City of Albuquerque

August 19, 2002

Re: Certification Submittal for Final Building Certificate of Occupancy for
Tiny Bubbles Car Wash, [L-18 / D065]
1225 San Pedro S.E.
Architect's Stamp Dated 08/16/02

FILE: 010801 - CAR WASH	DRAINAGE AND GRADING PLAN FOR TINY BUBBLES CAR WASH LOCATED AT TRACT "C", BLOCK 32, VIRGINIA PLACE	DATE/REVISION: 01/24/02 - Change Vacuum Location and Equipment Room Size
		SHEET NUMBER: 2

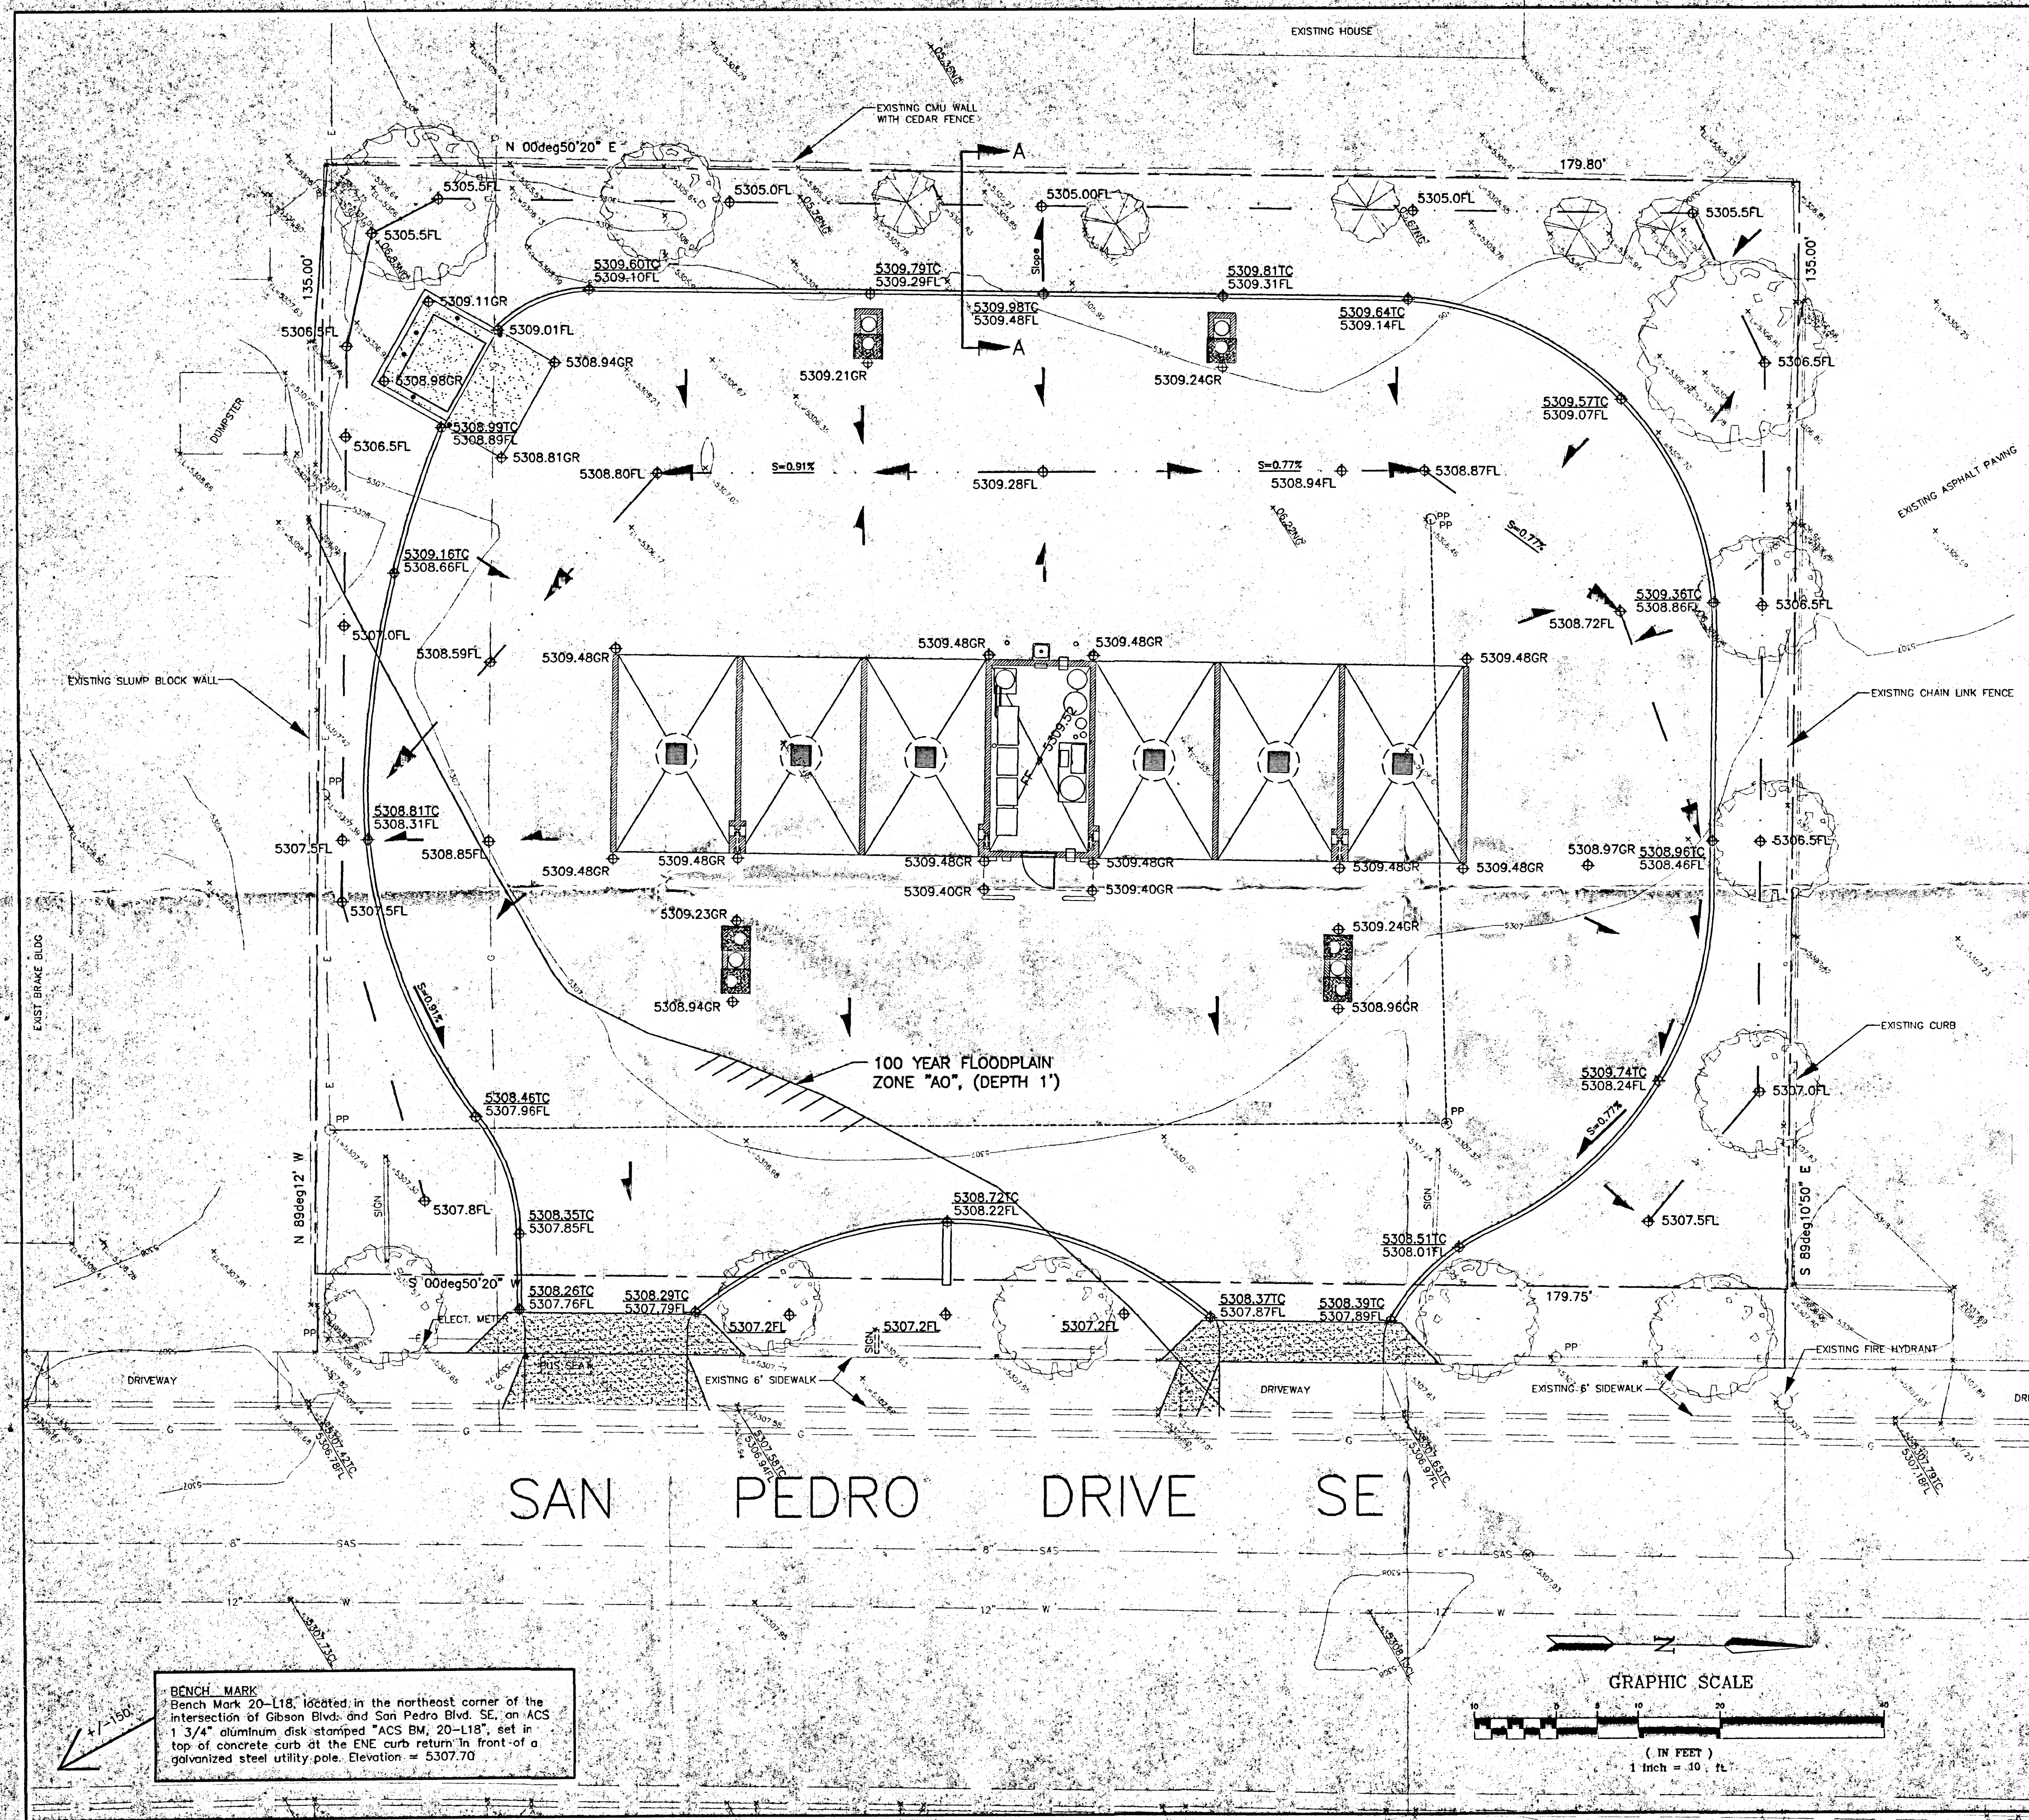
Please attach a copy of this approved plan to the construction sets prior to sign-off by Hydrology. Please be advised that a minor correction be made to your plan indicating that the downstream capacity flow will head west on Gibson Blvd rather than San Pedro Drive.
